KITTITAS COUNTY COMMUNITY DEVELOPMENT SERVICES

May 6, 2014

RE: Hansen Short plat, (SP-13-00007)

The Kittitas County Community Development Services Department has determined that the Hansen Short Plat (SP-13-00007) is a complete application and hereby grants *conditional preliminary approval* subject to the following conditions:

HANSEN SHORT PLAT
PART OF SECTION 8, T. 17 N., R. 18 E., W.M.
KITTITAS COUNTY, WASHINGTON

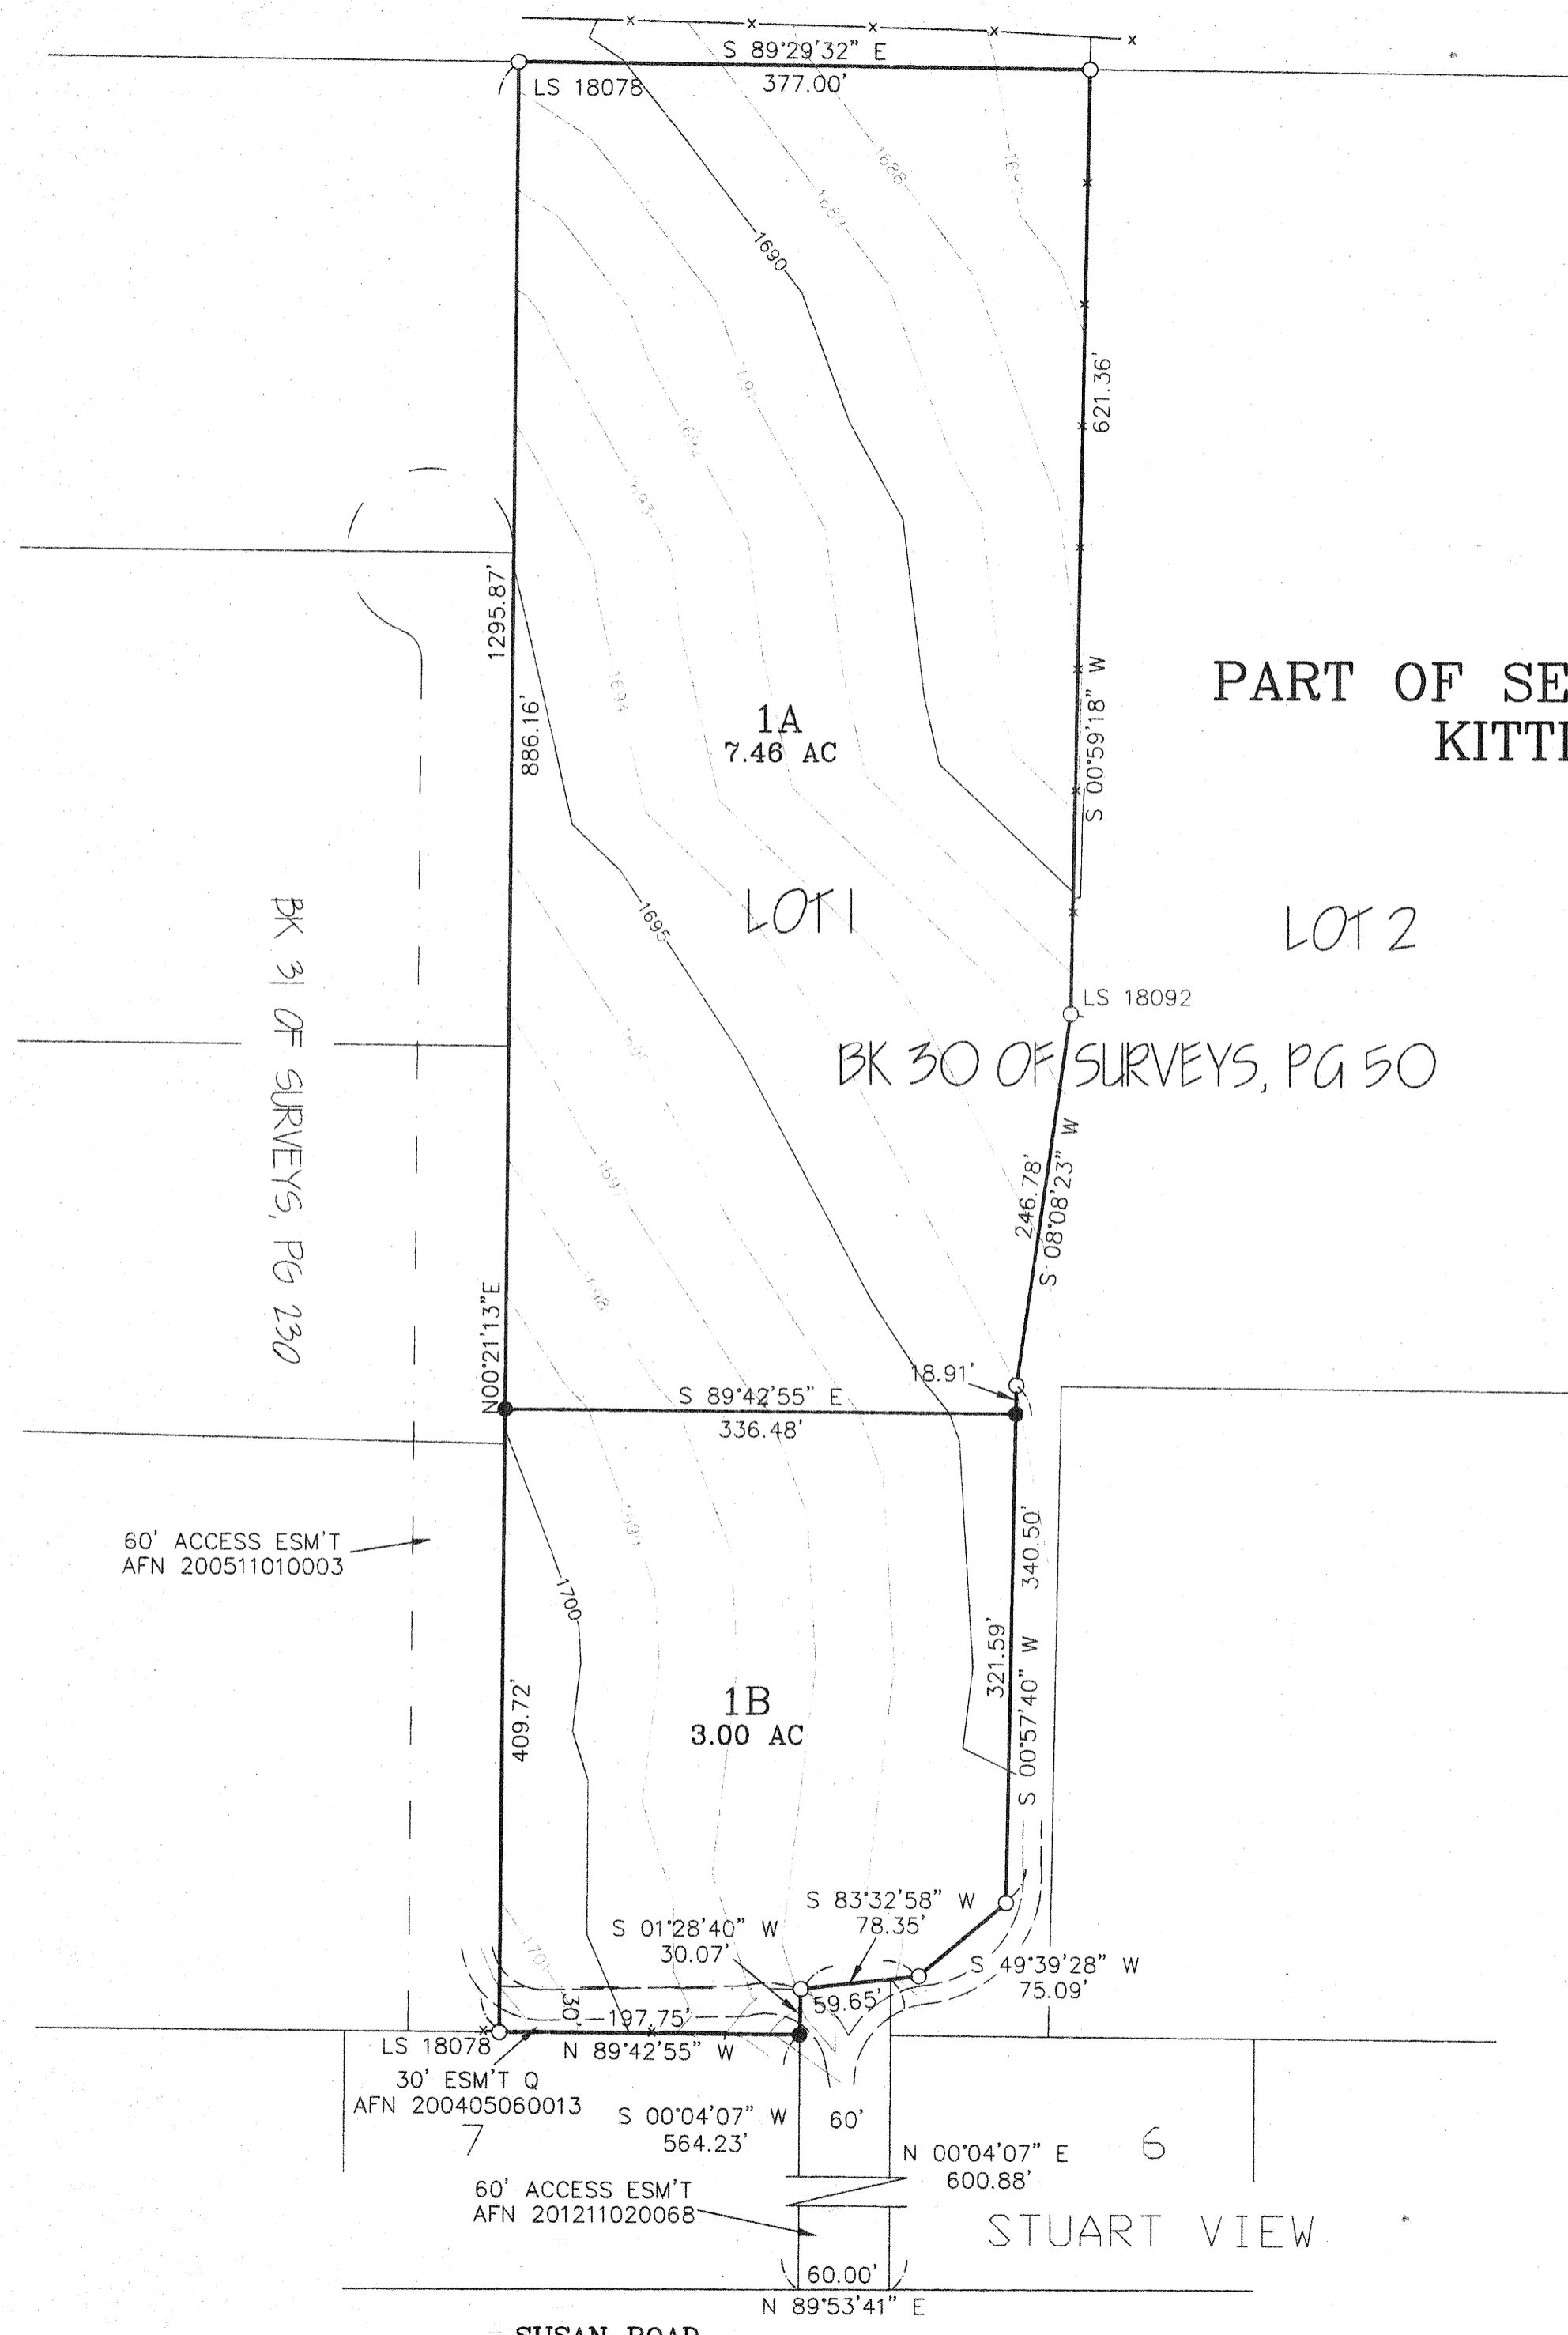
1. Both sheets of the final mylars shall reflect short plat number SP-13-00007 and an accurate legal description shall be shown on the face of the final plat.

5. A statement regarding the contemplated sewage disposal, water supply, and drainage improvements for the proposed subdivision shall be reflected on the final mylars.

17. Private Road Improvement: Access from Susan Road to the cul-de-sac shall be constructed as a Low-Density Private Road. See Kittitas County Road Standards, 9/6/2005 edition.

- a. Access easements shall be a minimum of 60' wide. The roadway shall have a minimum width of 20', with 1' shoulder, for a total width of 22'.
 - b. Minimum centerline radius will be 60'.

18. Cul-de-sac: A cul-de-sac turn-around having an outside right-of-way or easement diameter of at least 110 feet shall be constructed at the closed end of all dead-end roads serving 3 or more lots. The driving surface shall be at least 96 feet in diameter. Cul-de-sacs must also conform to the requirements specified by the 2006 International Fire Code. Contact the Fire Marshal regarding any additional cul-de-sac requirements.
